2 Swiss Cottages, Yapton Lane
Walberton, Arundel
West Sussex. BN180LS

I am writing in objection to WA/20/26/PL.

Drawing Title: PROPOSED LIGHTING PLAN
Drawing Number: 148_06
Date: August 2025 Scale: 1:250 @A1

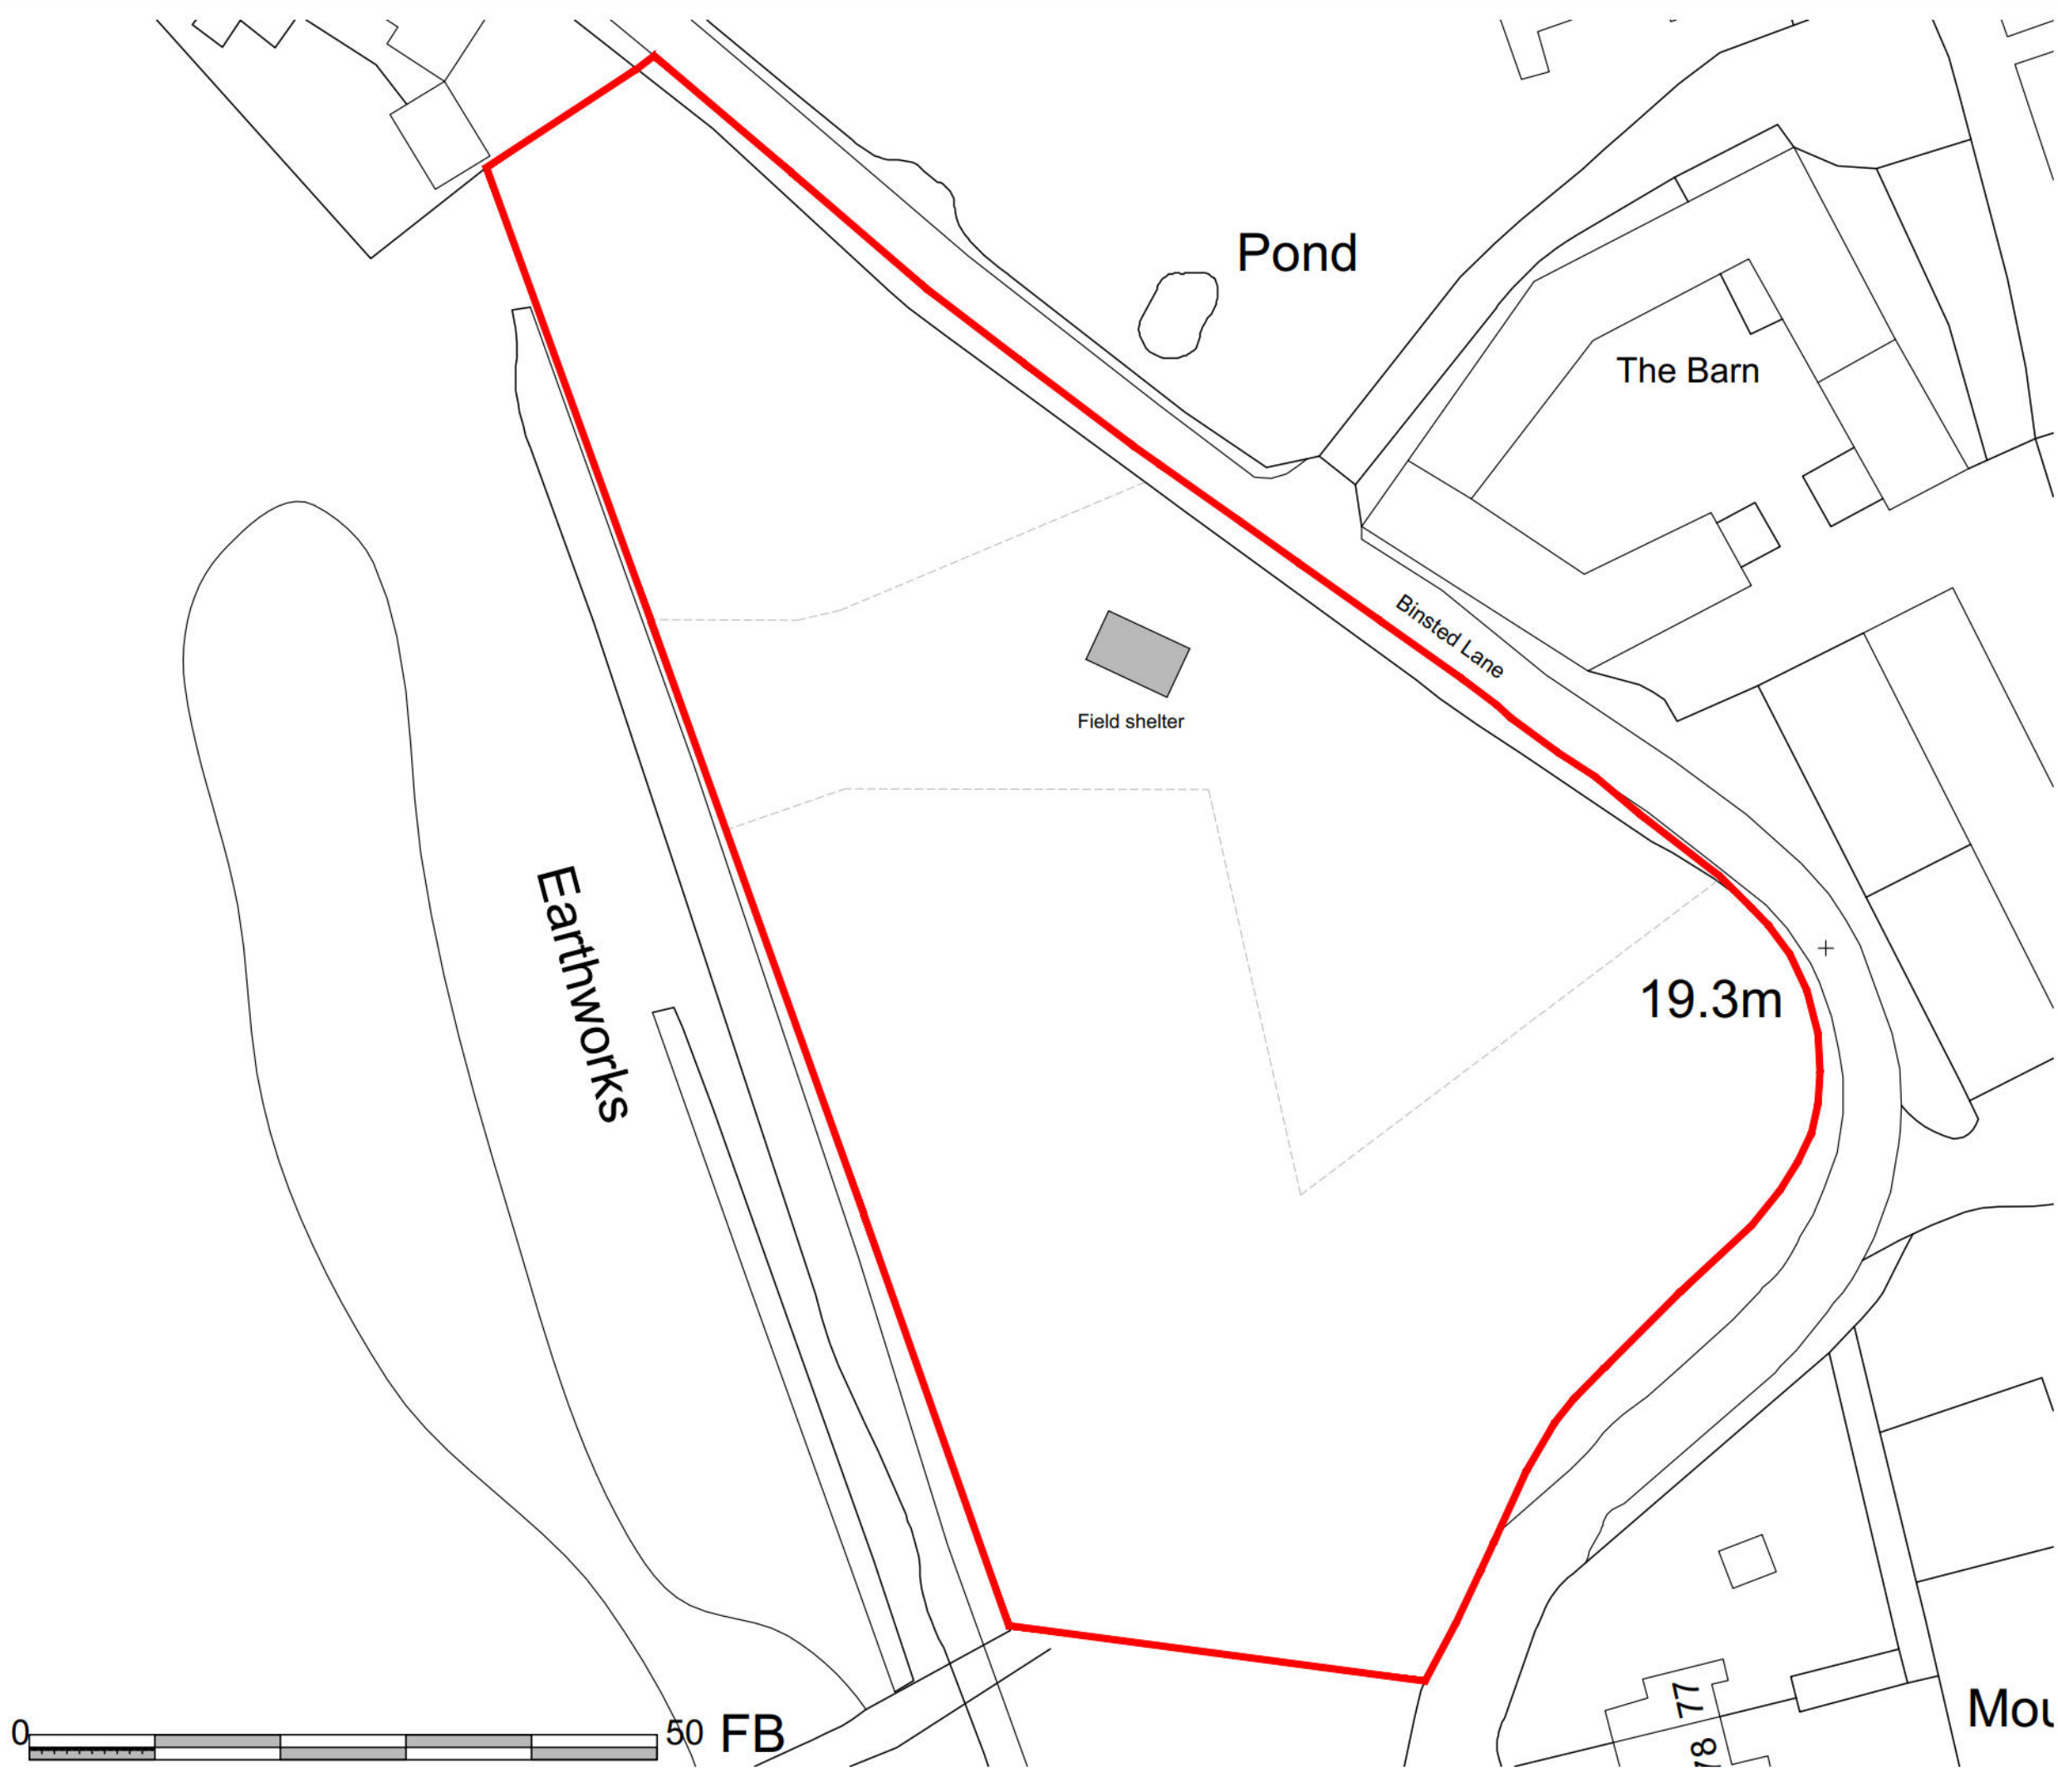
1. There has been lighting installed in the development which we can see from our garden throughout the night.
 - Previously we have had bats flying through the rife valley and up to our house which I have not seen since the installation of the lights.
 - I have seen a barn owl, on several occasions, in the adjacent part of the golf course prior to the installation of the lights, but not since.
 - We are part of the dark skies area – I have taken photographs of the aurora borealis from Binsted church looking north, which is now interrupted by the lighting at the glamping site.
 - *view from our garden at 00.30 hours that used to be completely dark and now is not.*
